CITY OF ALBUQUERQUE

Re: Christina Kent Day Care
205 Coal Ave SW
30-Day Temporary Certificate of Occupancy
Transportation Development Final Inspection
Architect's Stamp dated 01-14-25 (K14-D234)
Certification dated 08-13-2025
TRANS-2025-00220

A1 TRAFFIC CIRCULATION LAYOUT

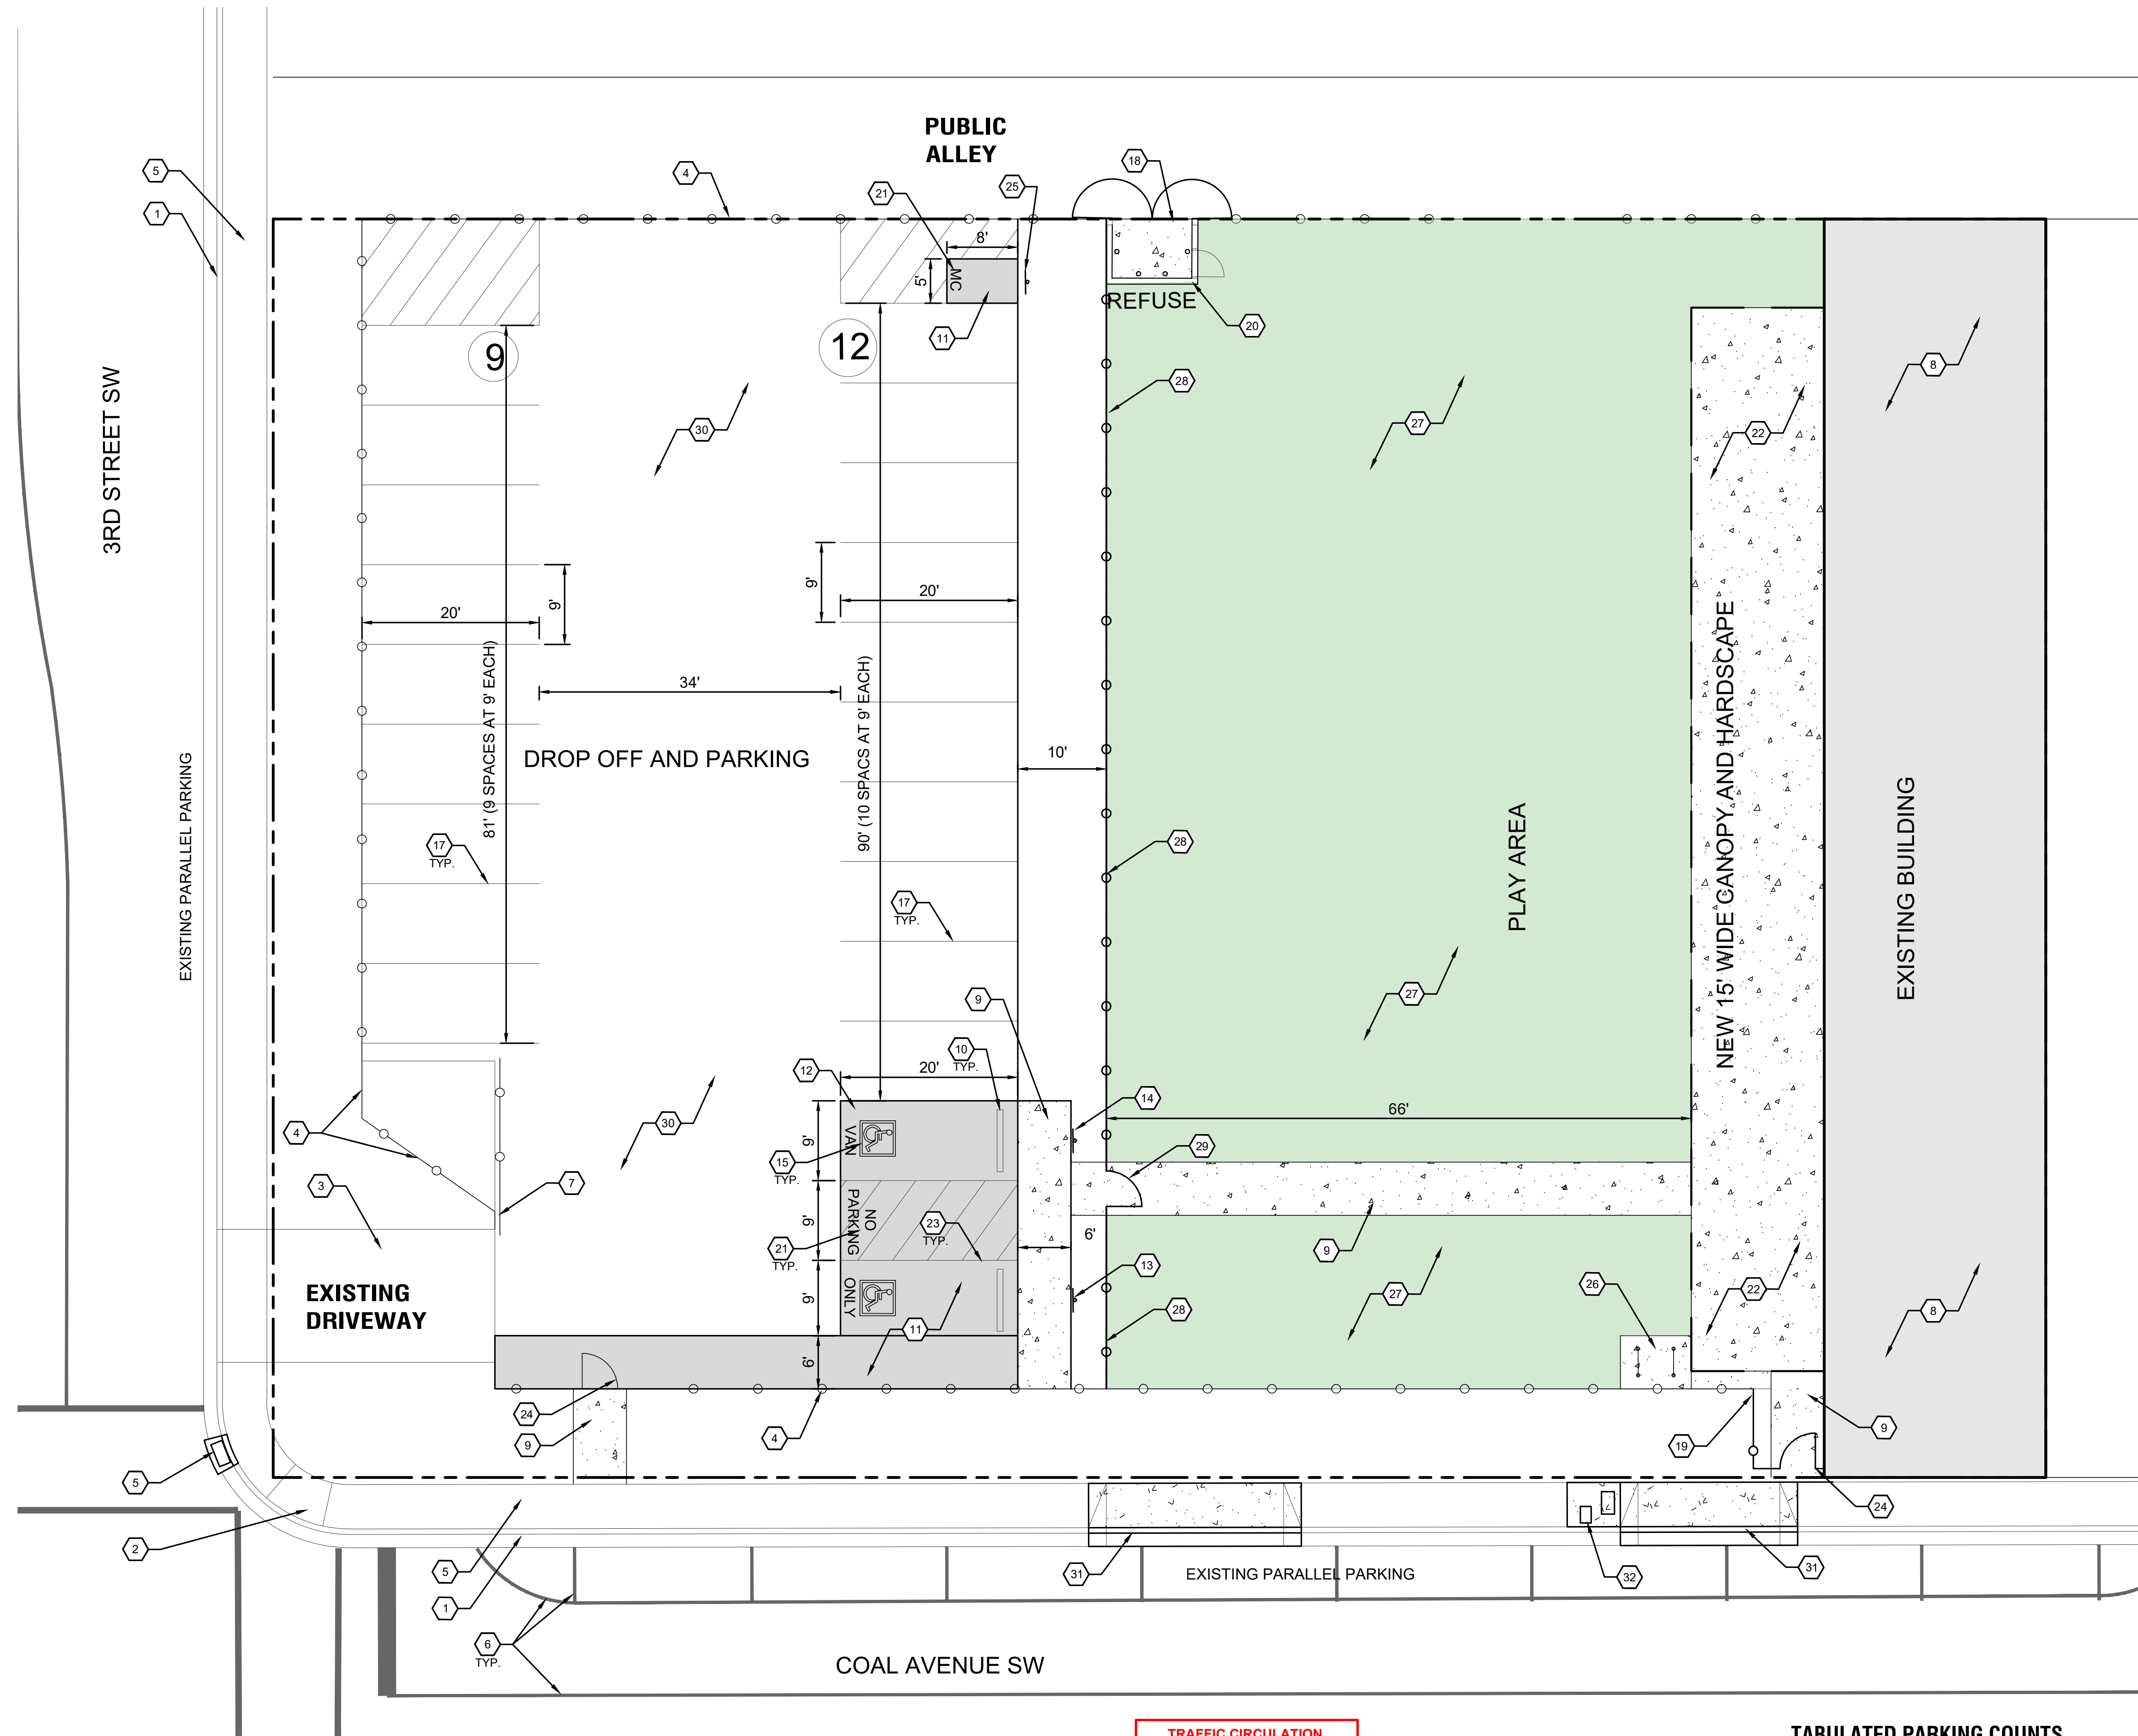
1. Anchor down bike rack.
2. Per the City requirements and approved site plan, All broken or cracked sidewalk must be replaced with sidewalk and curb & gutter.
